SYDNEY METRO VICTORIA CROSS OVER STATION DEVELOPMENT

Thank you for the opportunity of commenting on the two Victoria Cross over station development applications. The first being the Section 4.55(2) application to modify the SSD consent (SSD17_8874) (Council ref: DA.349/19/2) and the second being the development application for the over station development by Lend Lease (SSD_10294) (Council ref: DA.350/19).

Section 4.55(2) application to modify the SSD consent (SSD17_8874) (Council ref: DA.349/19/2)

Development Application for the over station development (SSD_10294) (Council ref: DA.350/19)

Picture 4 – Proposed Southern Elevation
Source: Bates Smart

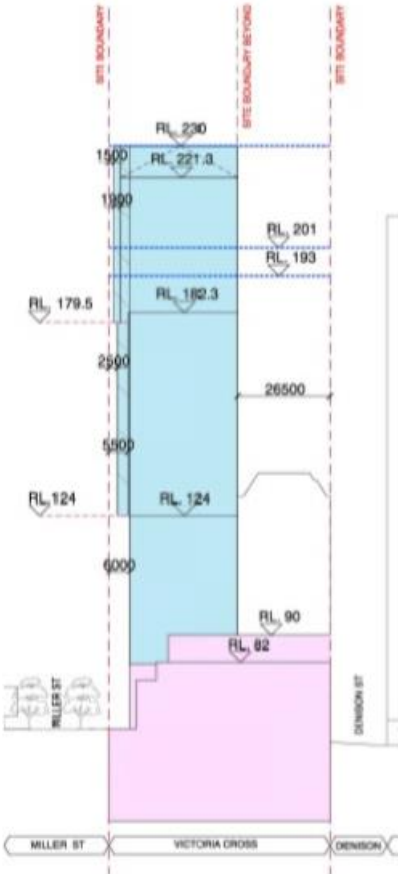
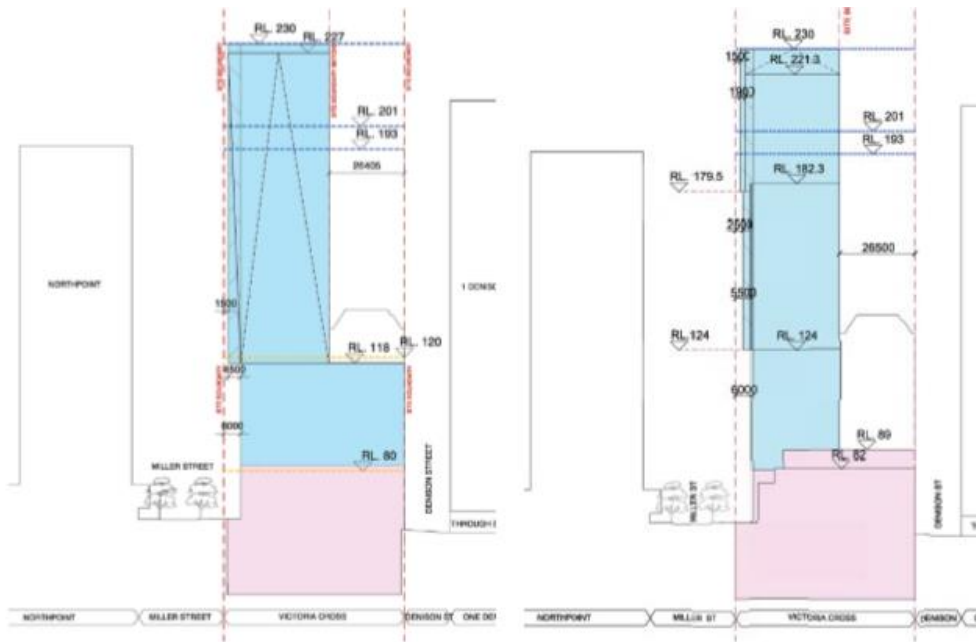
Council did not support the Miller Street setbacks approved by a Clause 4.6 (variation to development standard) request. The proposed changes to the envelope and shape of the tower might be an improvement but are still not supported. Council character statement controls requires a podium with tower setback of 5m. The podium height consistent with the MLC is considered acceptable.

The proposal features a reverse podium which is inconsistent with every recent development in the CBD and Council's character statement for the CBD as part of its DCP. The articulation of the tower could occur within the 5m setback behind the podium building line at RL 118 with a weighted average of 5m at least. Council could consider a variation of the entire setback less than the weighted average of 5m or at least in line with the podium. The tower should not be closer to the street than the proposed podium but setback to be consistent with all of the other buildings in the CBD. This would also assist in reducing the building's dominance to Miller Street.

The application should be amended to comply absolutely with the Miller Street setback for the entirety of the façade of the building which faces Miller Street.

The modifications to the Concept approval are considered reasonable and an improvement subject to the tower being setback on the Miller Street faced to at least be in line with the podium.
